RESPONSE TO REQUEST FOR FURTHER INFORMATION - 104-116 REGENT STREET, REDFERN

This letter has been prepared by Urbis on behalf of Wee Hur and relates to State Significant Development Application (**SSDA**) at 104-116 Regent Street, Redfern (**SSD-12618001**).

This letter responds to a Request for Information (**RFI**) issued by the Department of Planning and Environment (**DPE**) on 15 July 2022. DPE requested responses to additional submission by City of Sydney, Sydney Metro and one public submission following their review of the Response to Submissions (**RtS**) report submitted by Wee Hur on 15 June 2022.

DRAWING SERIES  
Elevations  
DRAWING TITLE  
Northern Elevation + Southern  
Elevation

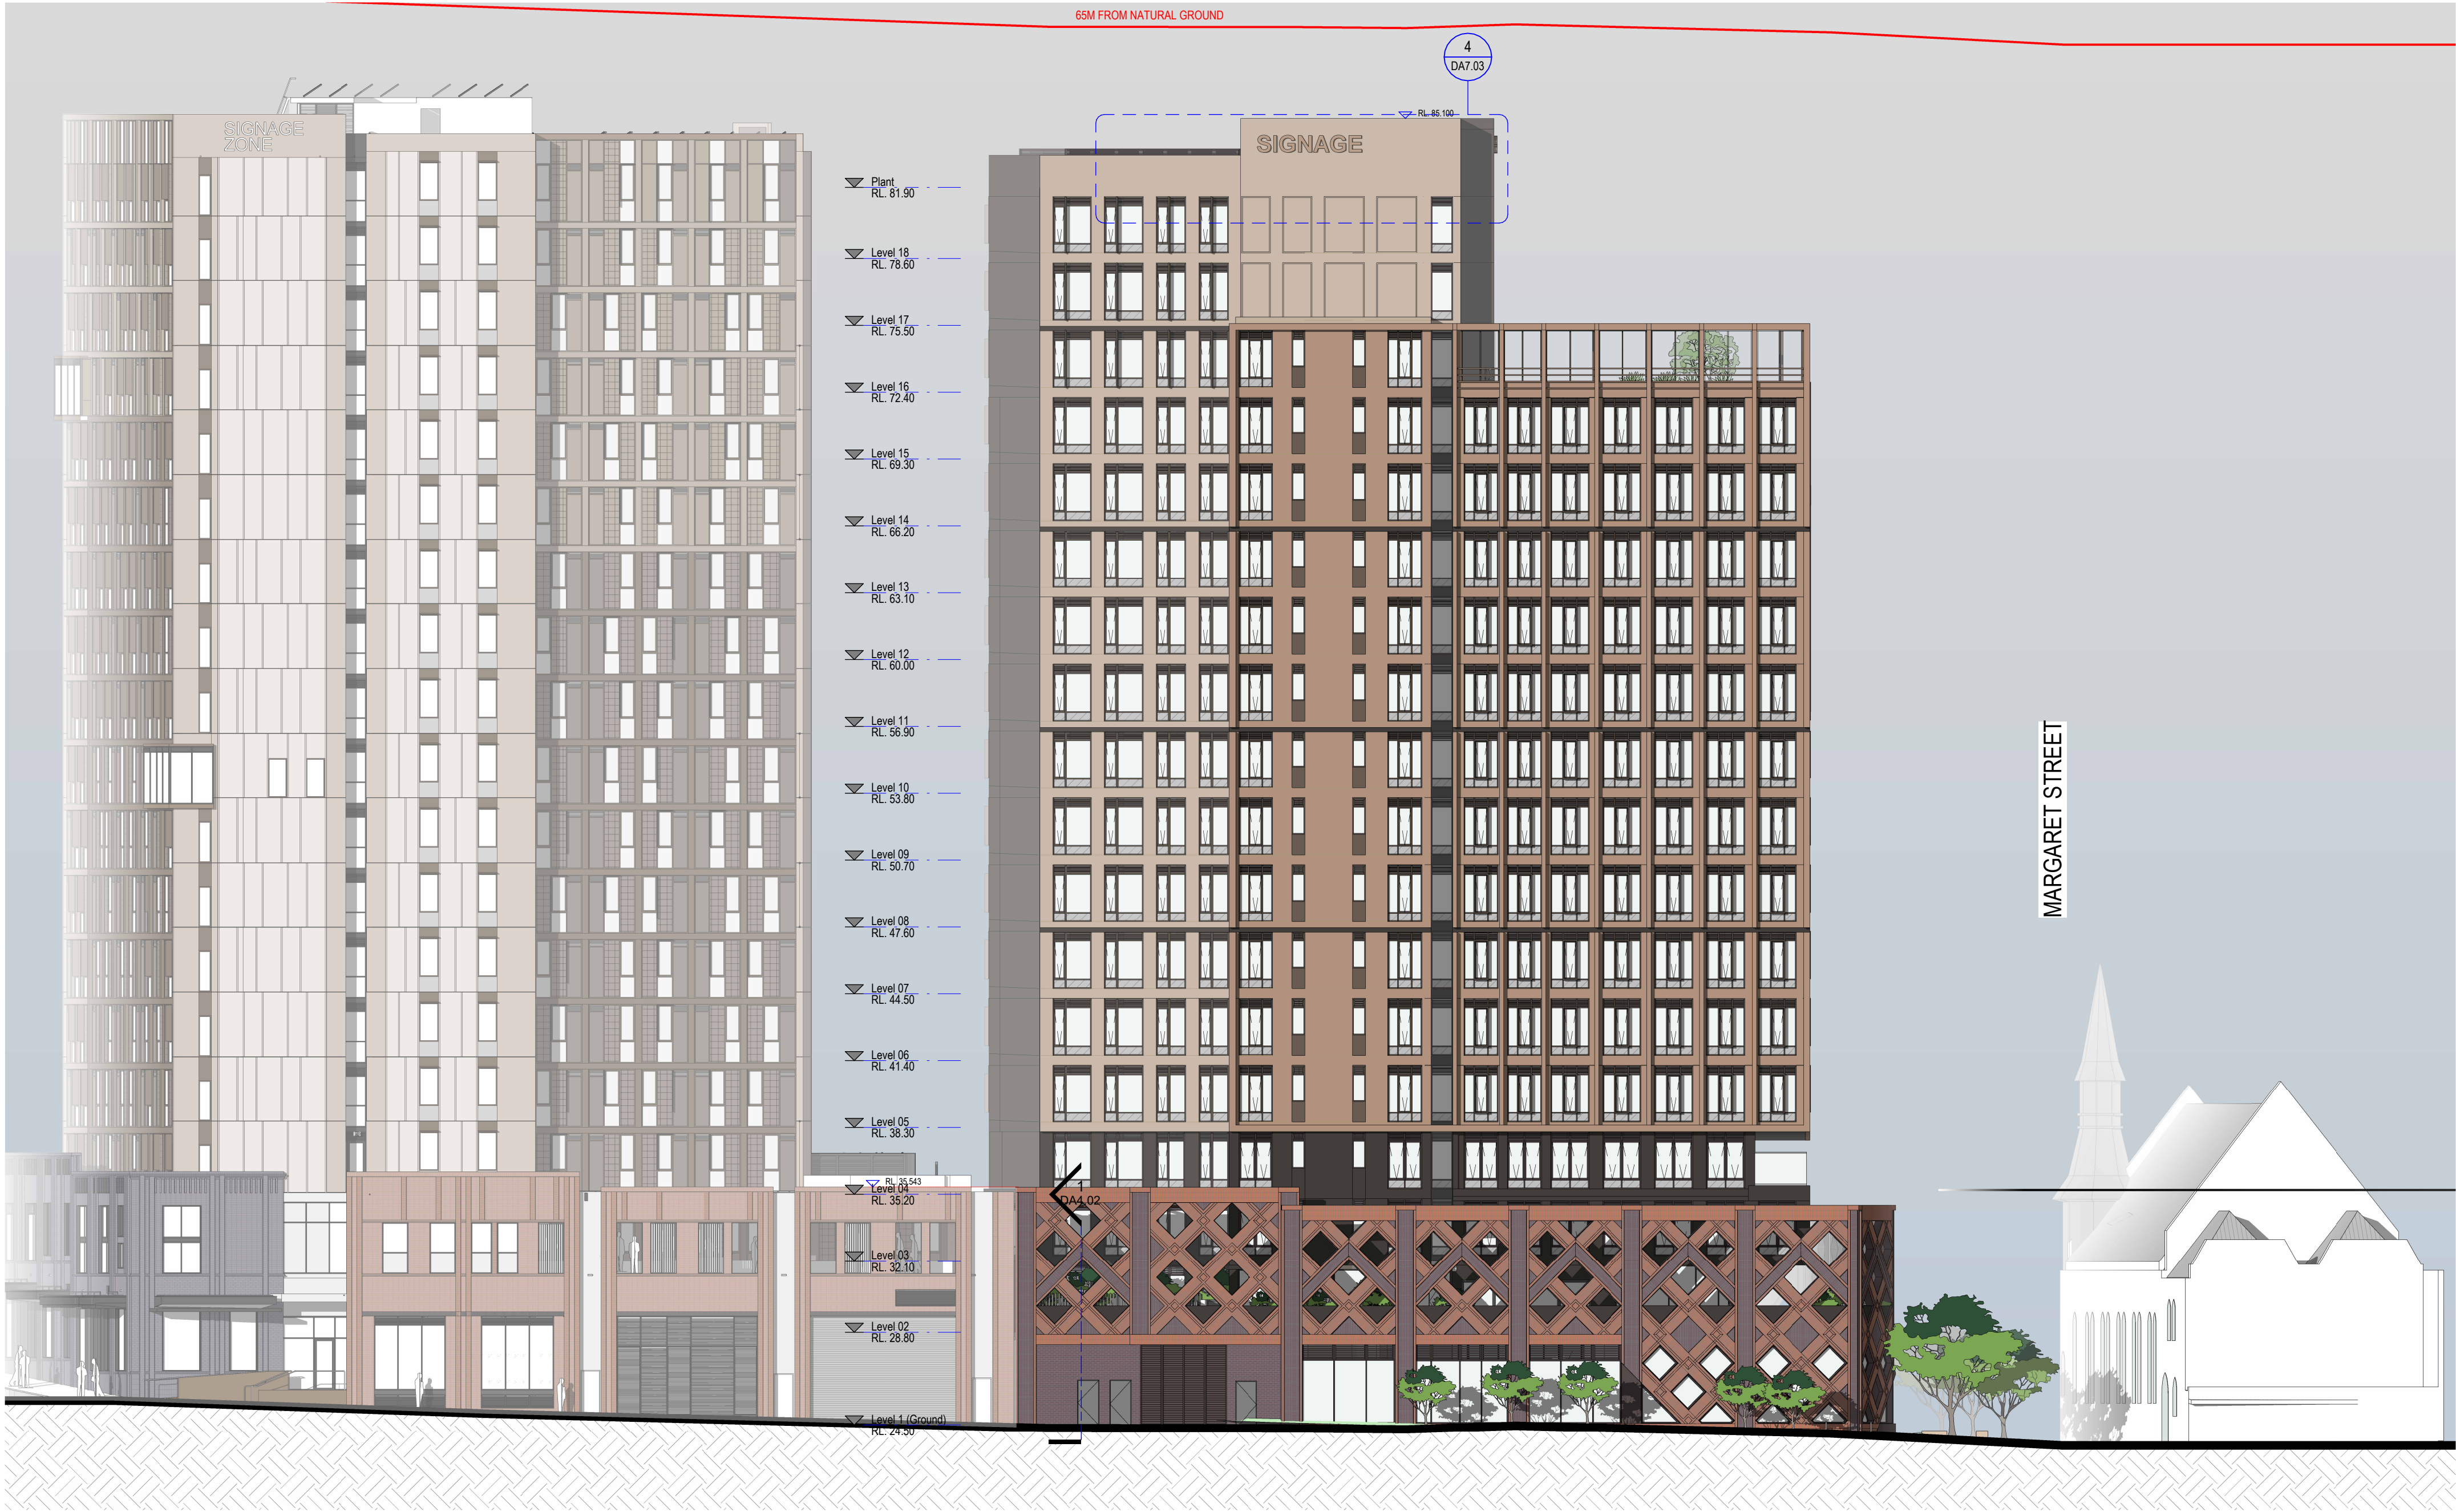
Comment	Response
<p>2. Building Expression and Public Art</p> <p>The RTS has sought to address the City's previous concerns regarding the blank building expression on the northern and southern elevations through the provision of reckli form liner patterns to create a textured and modulated façade. Public art is proposed to be designed and integrated in the reckli patterns.</p> <p>This response can be acceptable to the City if the facade can accommodate sufficiently thick form liner panels to deliver an artwork of depth in the façade. It is strongly suggested that an indigenous artist be engaged to produce any future artwork for the development, particularly with Redfern's strong historical links to Aboriginal people and culture.</p>	<p>Antoniades Architects have undertaken a visual study of the southern façade to understand the extent that it would be visible from different vantage points. The study (Appendix E) demonstrates the southern façade will be most visible on the uppermost five storeys.</p> <p>The project team has engaged a local indigenous artist Nicole Monks, who has created artworks for the adjacent 13-23 Gibbons Street and 90-102 Regent Street buildings. Taking inspiration from the weaving pattern of the podium façade, Nicole recommended that the proposed development could include a more feminine artwork in contrast to the masculine artwork of 90-102 Regent Street building. Nicole has recently undertaken a photographic workshop with award winning photographer Wayne Quilliam and the Brolga Dance Company. Nicole suggested incorporating an image of the dancers into the precast concrete.</p> <p>The project team are currently working through the copyright issues and permissions to use the image prior to engaging the precast manufacturer. The artwork will be 15.3 metres high and 5.8 metres wide and will be approved by City of Sydney as a condition of consent.</p>

DRAWING SERIES  
Photomontage  
DRAWING TITLE  
Signage Details

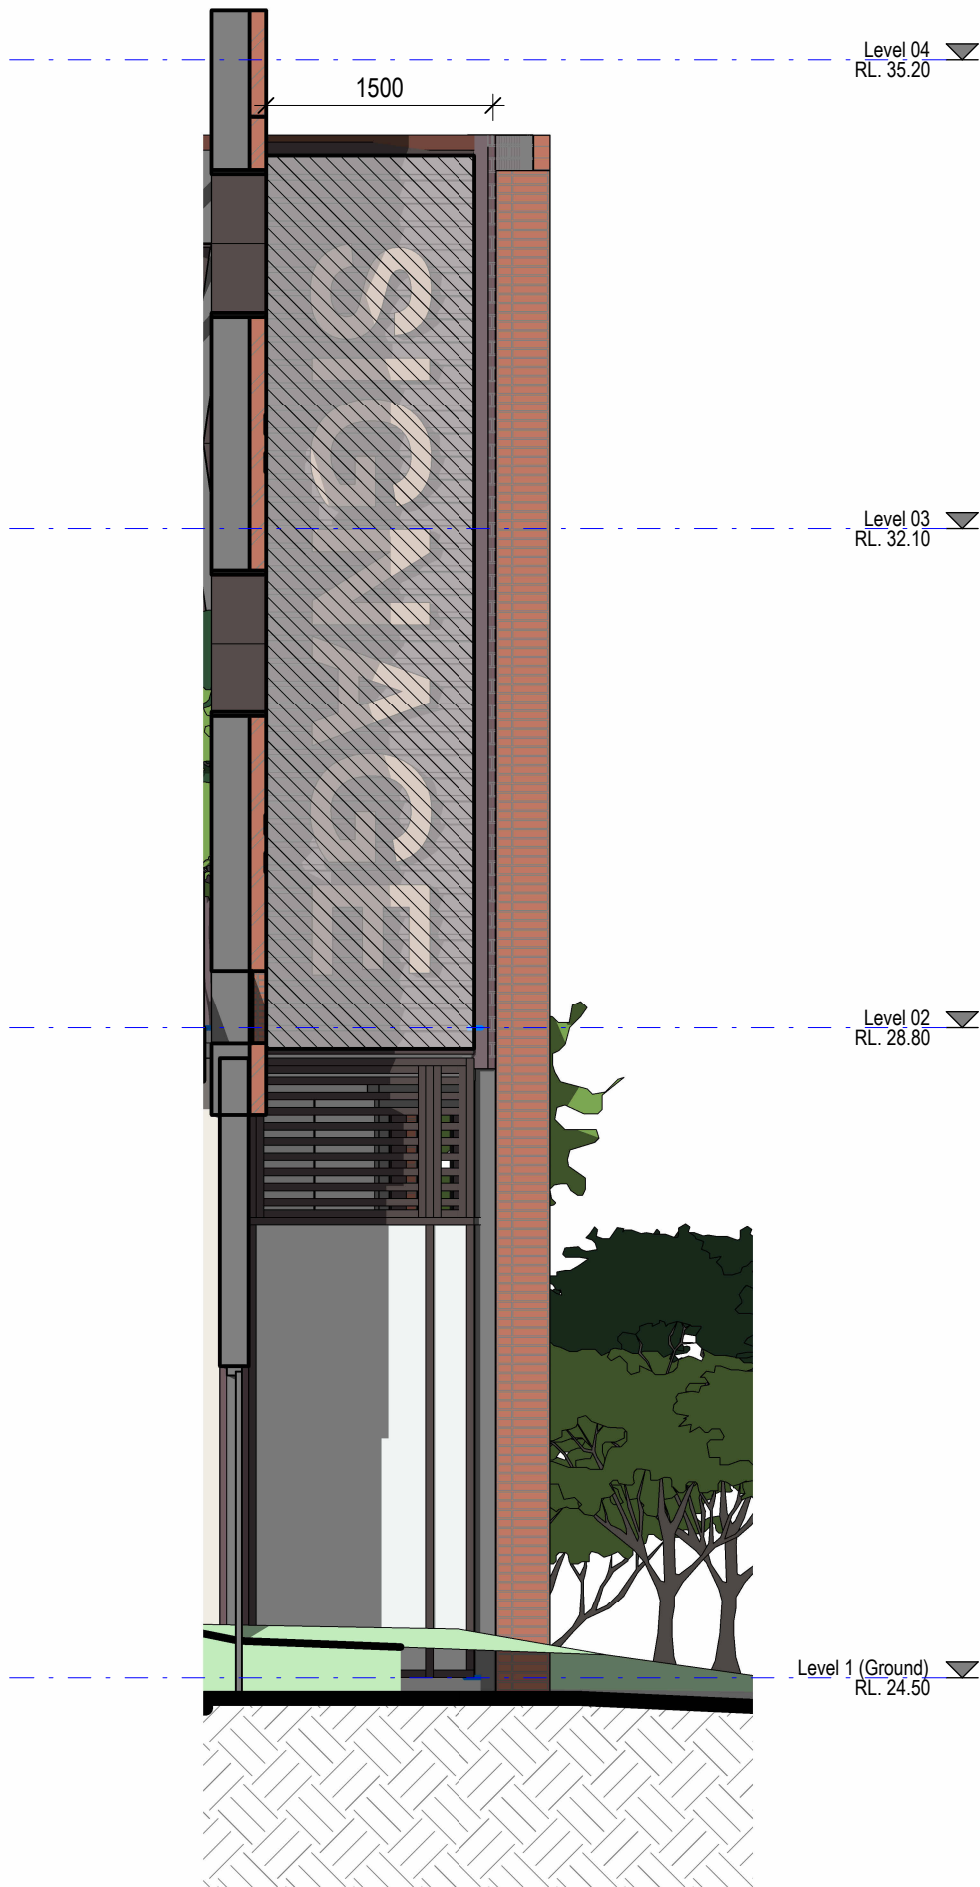
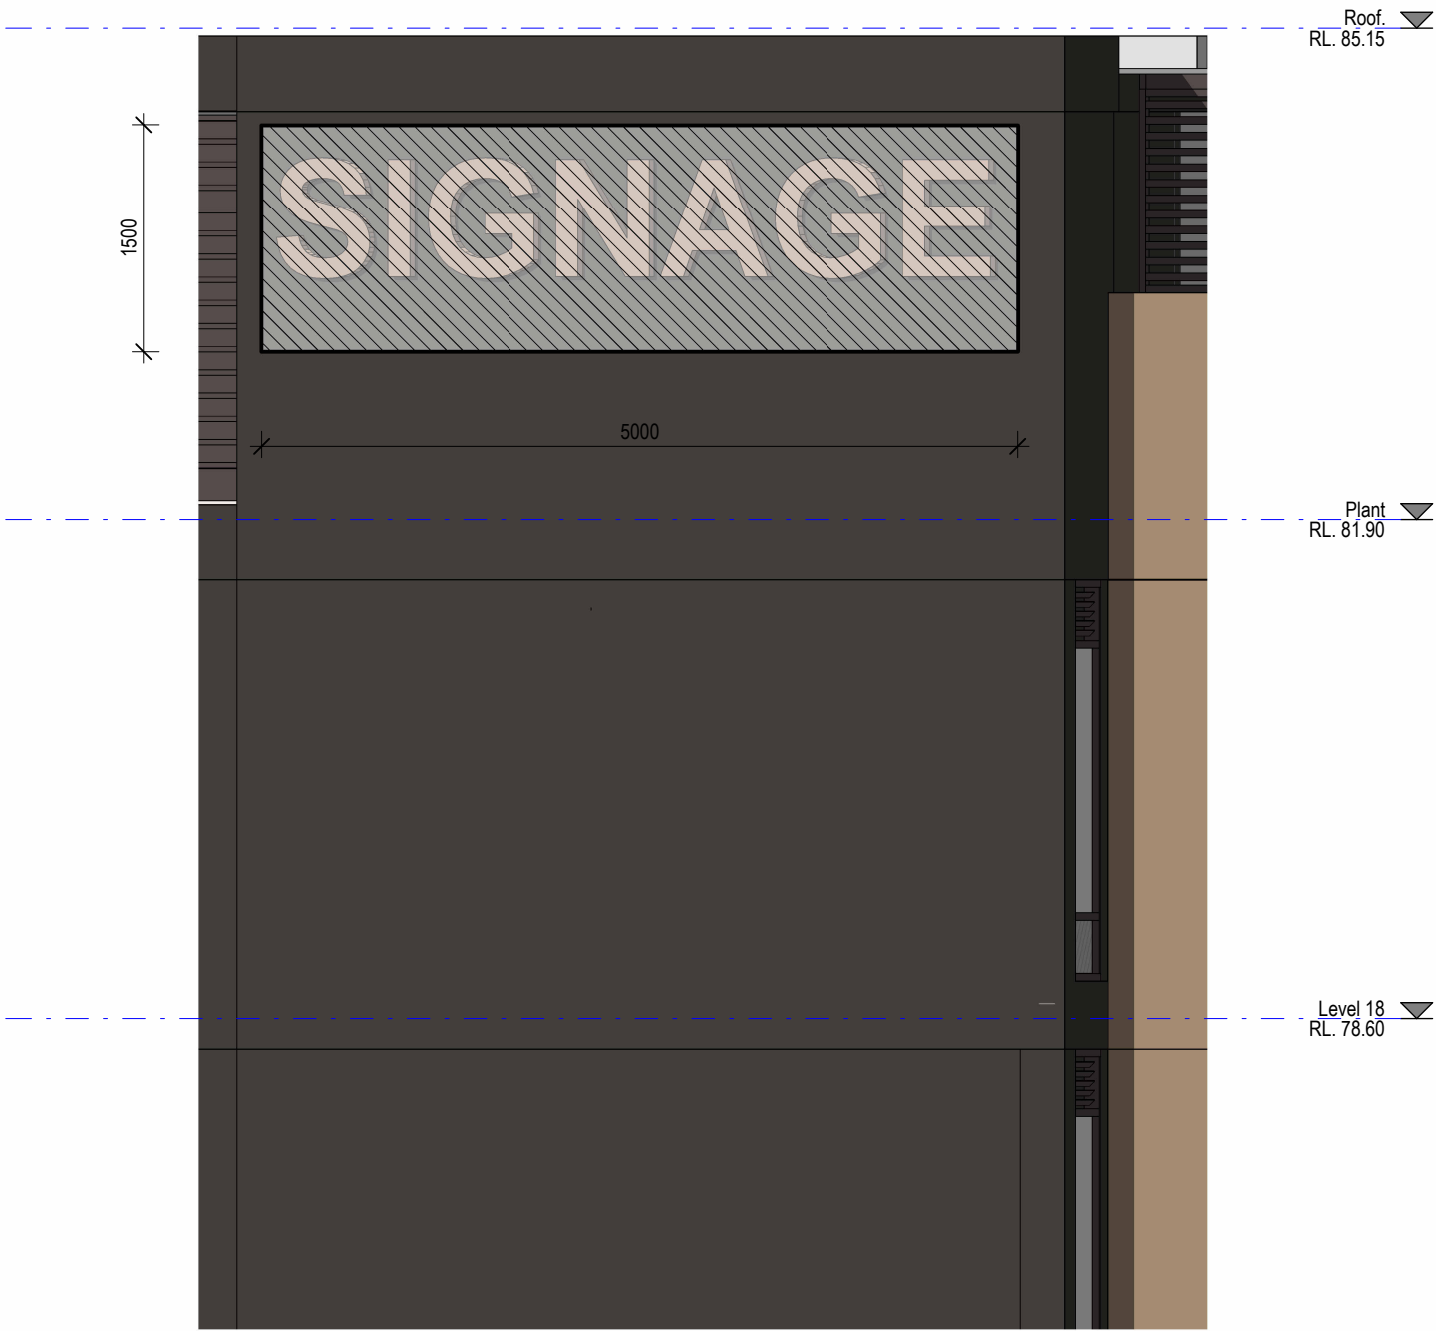
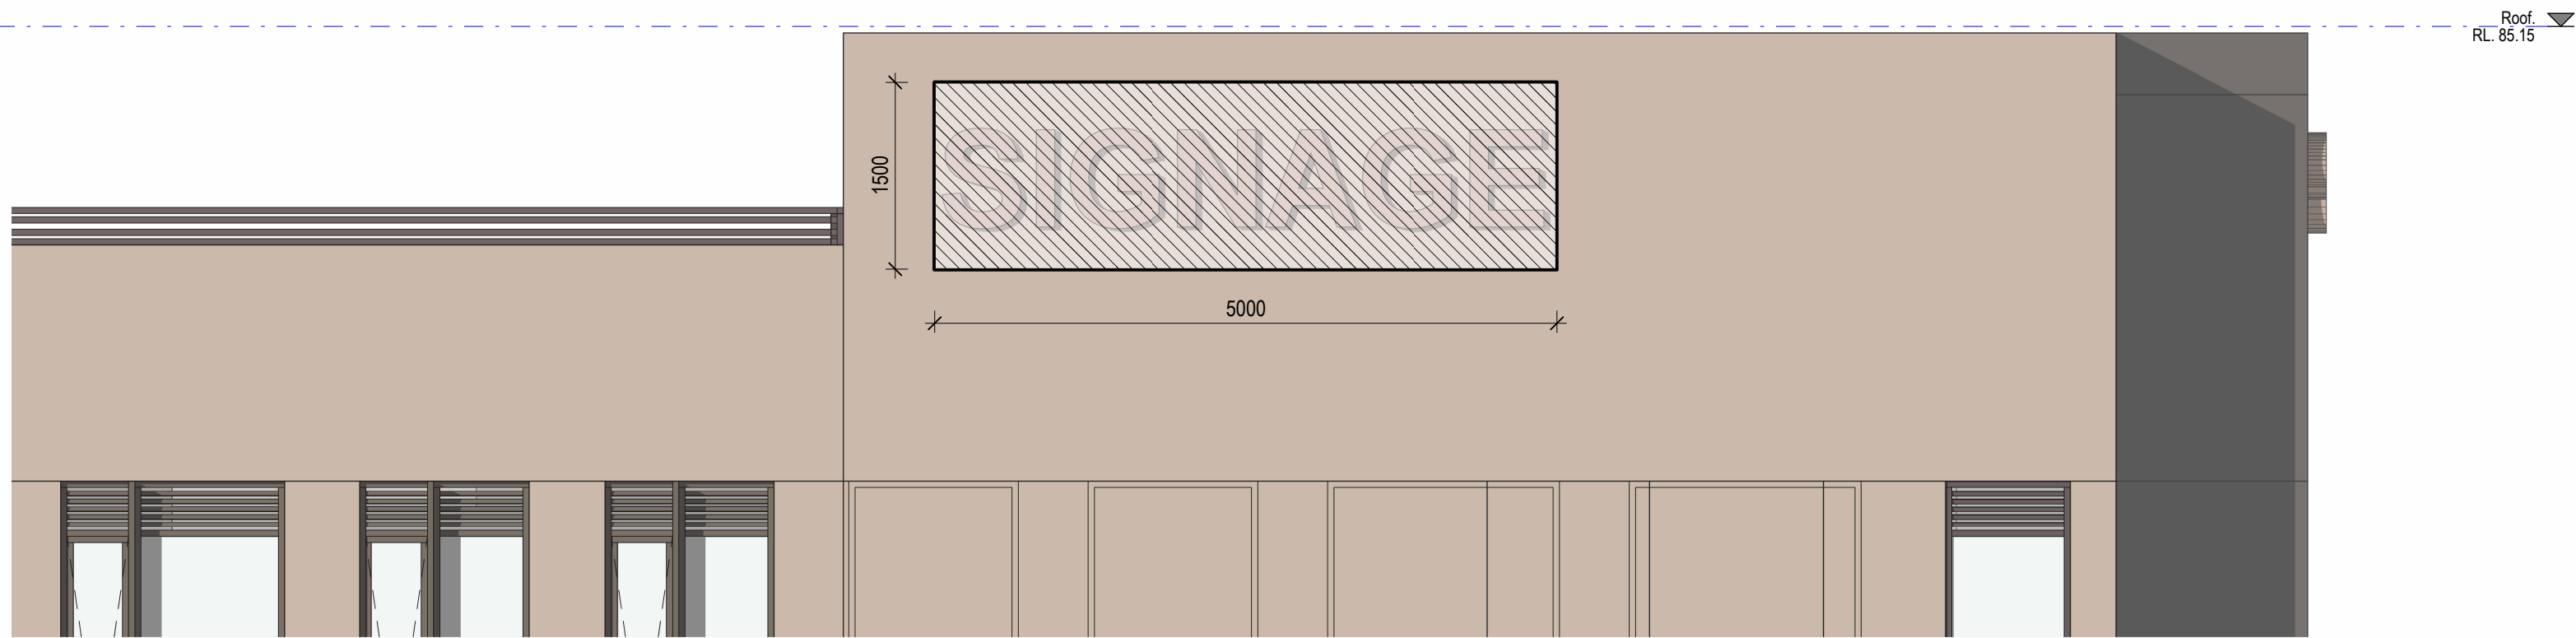
<p>c. Signage</p> <p>The City reiterates previous comments in that a signage strategy is required for the development in accordance with the Redfern Centre Urban Design Principles 3.4.2. The signage drawings relate to signage zones only and does not meet the minimum requirements of a signage strategy where signage for the entire development is nominated. There is no signage indicated for the retail tenancy. Accordingly, it is recommended that a separation application be made for a signage strategy and detailed signage for the site.</p> <p>Further, the William Lane podium signage is excessively wide and is not supported. A maximum 300mm width lettering is recommended, with individual lettering pinned on a quality finish wall.</p>	<p>Noted – an appropriate condition can be incorporated into the consent to provide for a Signage Strategy and the detailed signage via a separate DA.</p>
